Note / Memo

To: Devinda Kumarasinghe, Oxfordshire County Council
From: Juliet James
Date: 09 January 2024
Copy: -
Our reference: PC5143-RHD-ZZ-XX-ME-R-0001
Classification: Project related
Checked by: AF/AW

Subject: Parcel R, Kingsmere, Bicester (23/03073/HYBRID)

- 1.1.2 This Technical Note responds to the consultation response received from Oxfordshire County Council (OCC) dated 07/12/2023, which commented on the Transport Statement (TS) and Travel Plan (TP) documents. The TS and TP were prepared by RHDHV and submitted as part of the planning application (Ref: 23/03073/HYBRID).

2.4m x 43m Visibility Splays

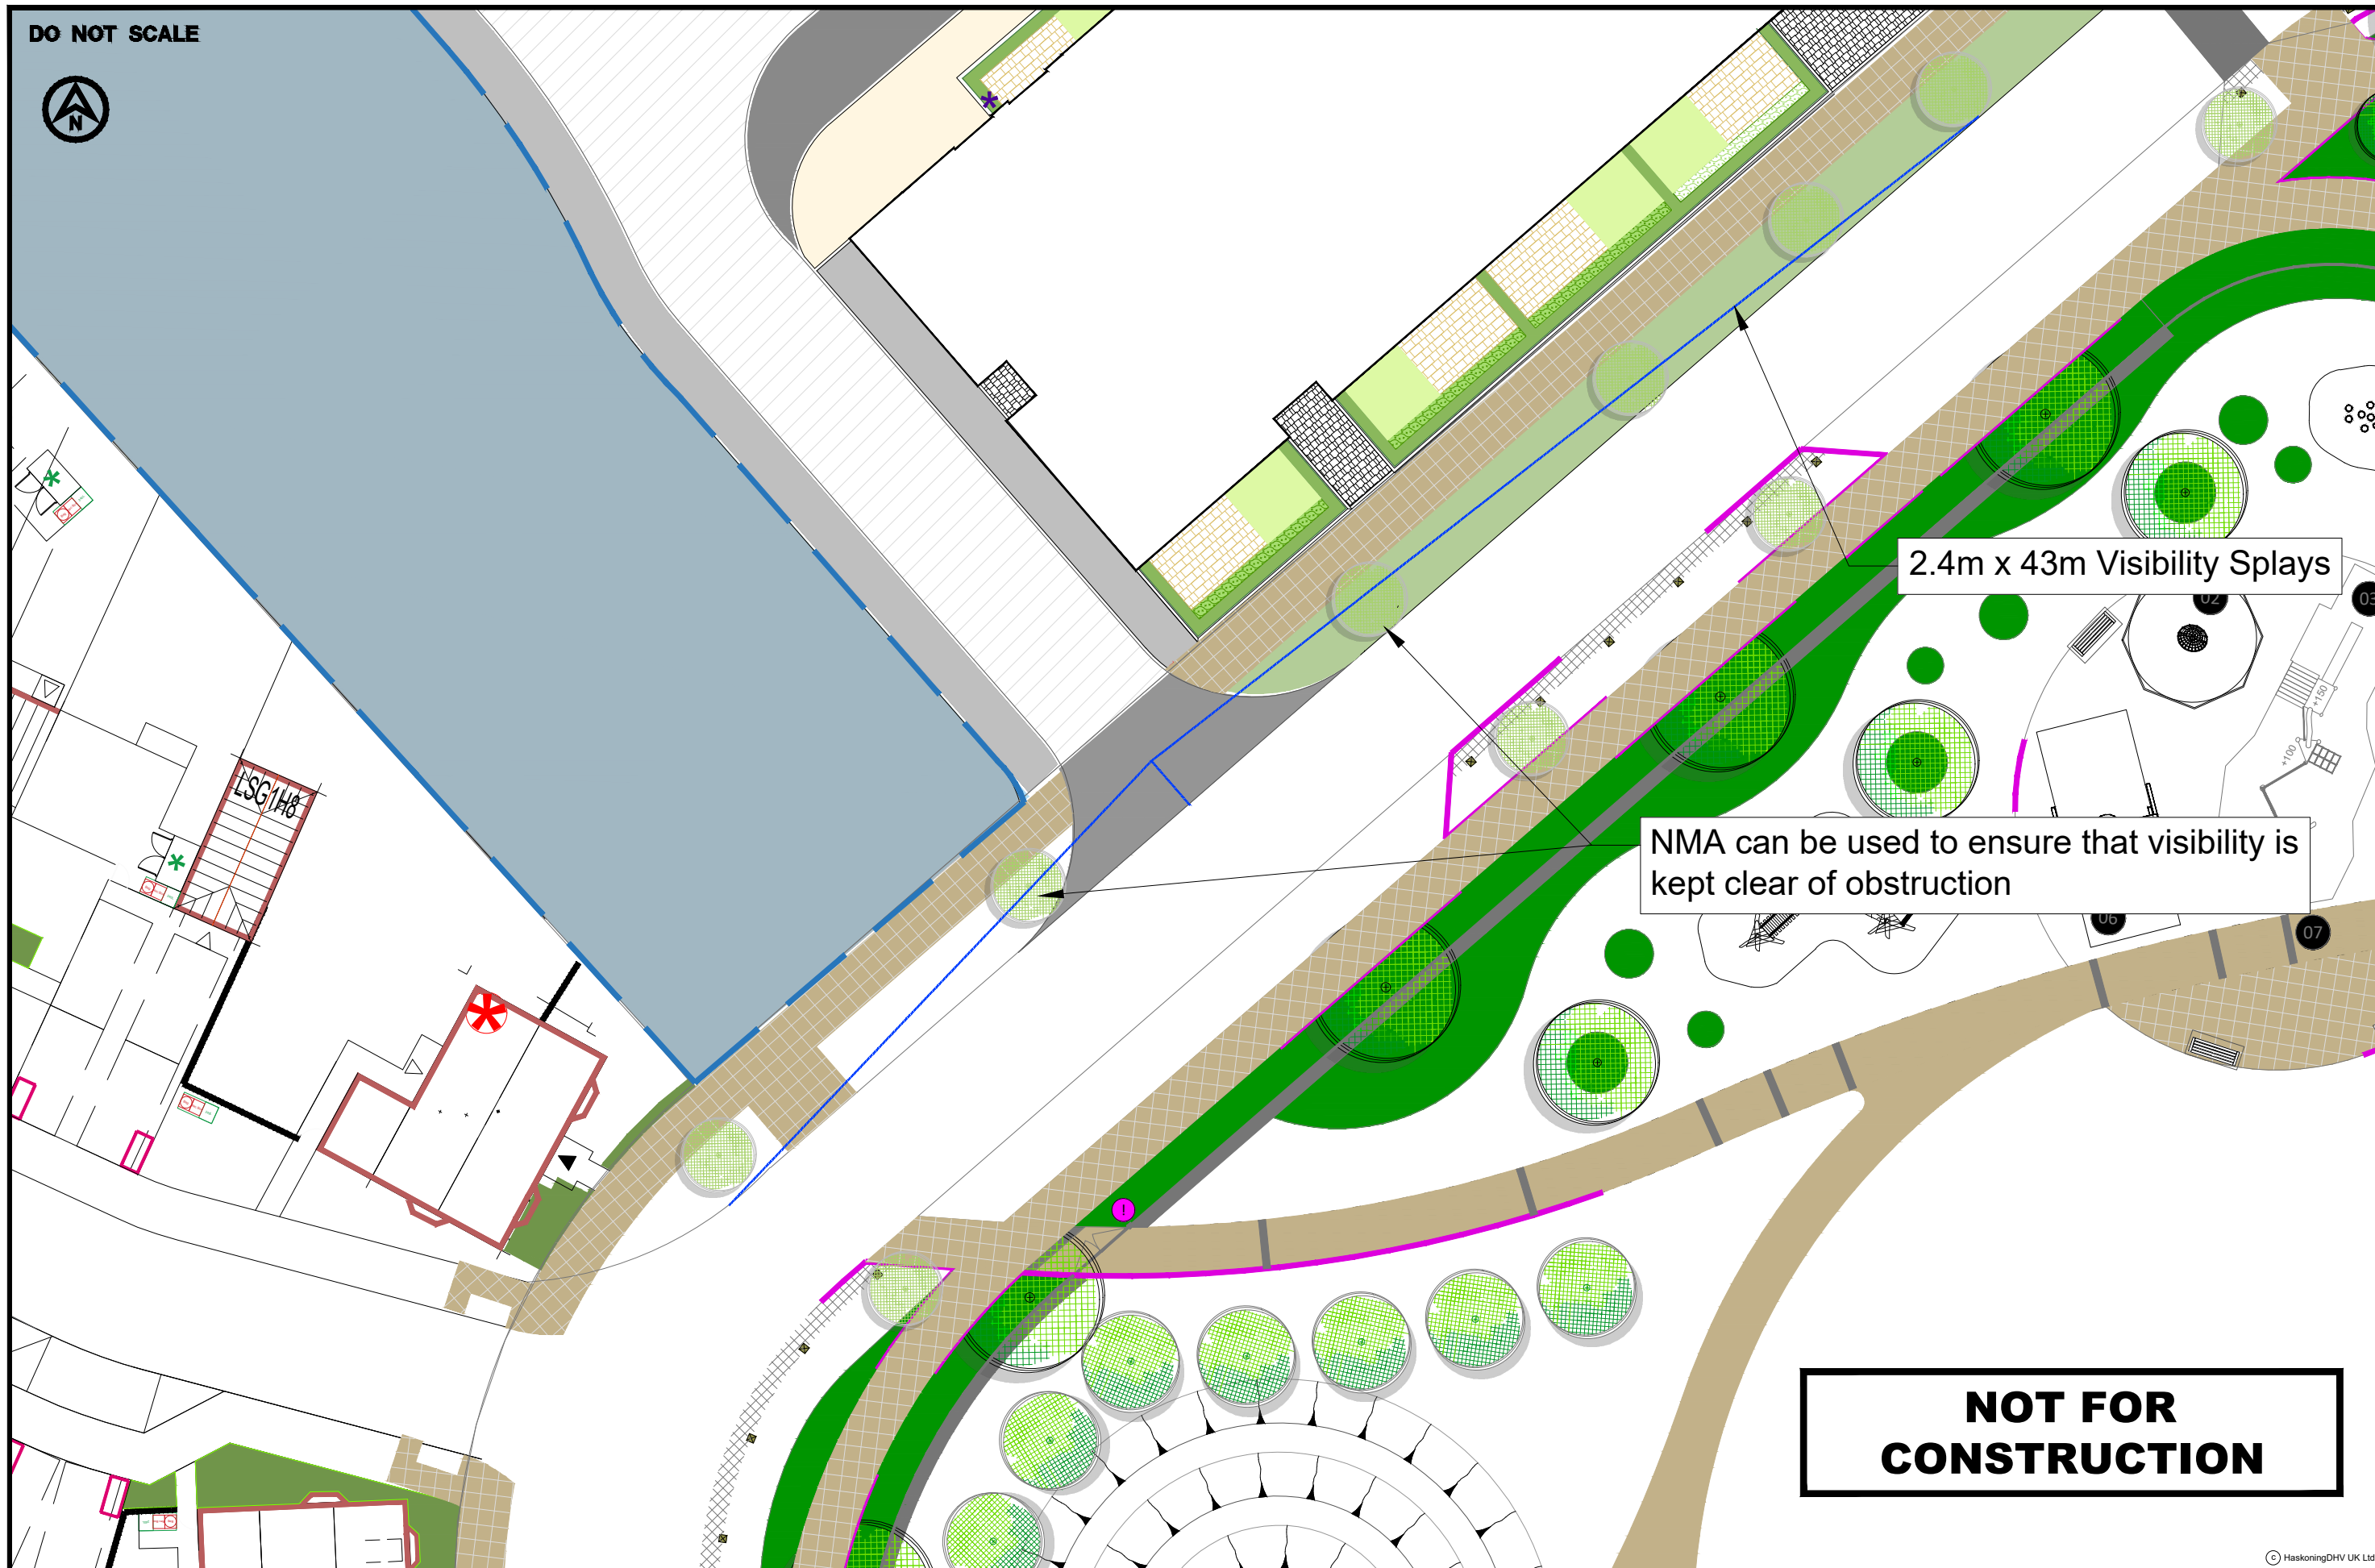
Although the required safe visibility splays appear to be contained within the public highway there appears to be possible obstructions within it (e.g. shrubs / wall). The visibility splay should be free of obstructions 2m high down to a point 600mm above the carriageway.”

- 5.2.1 An updated Site plan is included in **Annex E** with annotated dimensions.
- 5.2.2 It is agreed that visibility splays could be provided free of obstructions from a 2m height down to a point 600mm above the carriageway, with any associated planting within these zones adhering to these requirements. If required, this can be achieved.
- 5.2.3 It is noted, however, that the consented access arrangement for the plot has vehicular access with trees located within the associated visibility splay. **Insert 5.1** below illustrates the existing (consented) arrangement.

- 5.2.6 It is therefore proposed that the trees are retained unless Officers advise that the trees must be removed or relocated.
- 5.2.7 In addition to the junction visibility analysis pertaining to the main site access, visibility analysis of the internal junctions at the car park access points have been carried out and are provided at **Annex F** of this TN. It is noted that detailed approved applications within the wider masterplan area (example: Landscape Masterplan from application 19/02225/REM – Drawing 2829-5-DR-5000-S4-P4) have used a Sight Stopping Distance (SSD) of 15m for internal ‘minor’ junctions and a similar approach has been applied to this analysis.
